Salah Nouaim
11380 US 401 N
Fuquay Varina, NC 27526
RE: Dabbing Chicken

A plan review was received by this office concerning the construction of the above referenced facility. The plans are not approved and the application is being returned at this time with the following comments:

Dabbling chicken
Floor plan

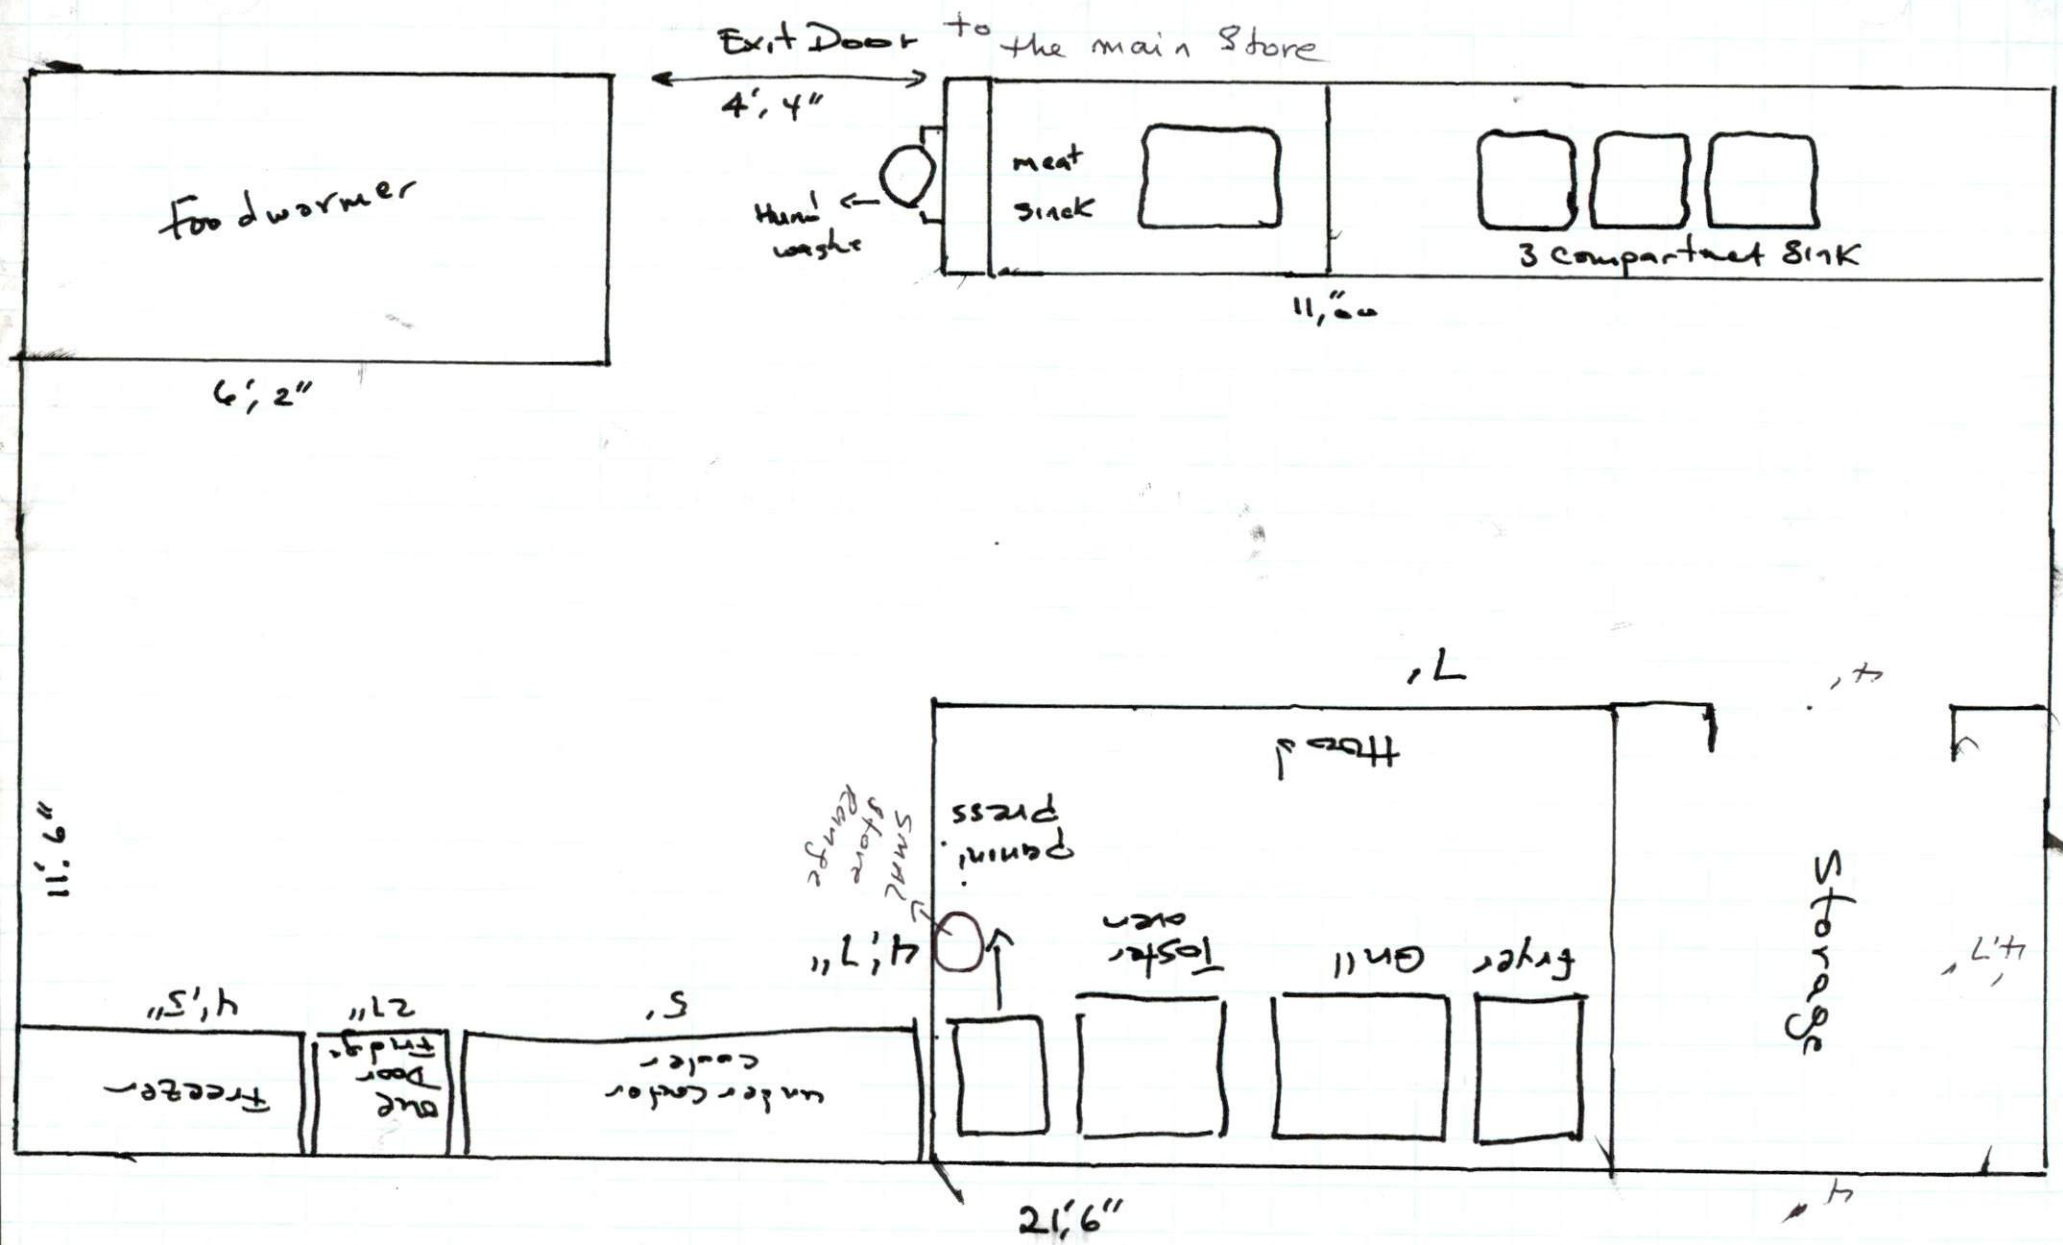
- The application indicates that a separate room designated for dry storage is not provided. Do you intend to use the back storage room off the main store area? If this room is used for storage it shall be indicated on the application and provide a site plan with equipment shown on the site plan.

- Manual dishwashing sink compartments and drainboard measurements are not correct. Provide correct measurements on the application for these items.
- Be more specific as to where the employees' personal items will be stored. You stated "in the back". Describe where this is in relation to the kitchen. If you intend to use the storage room in the back of the store, than indicate on the site plan where the employees' items will be stored.
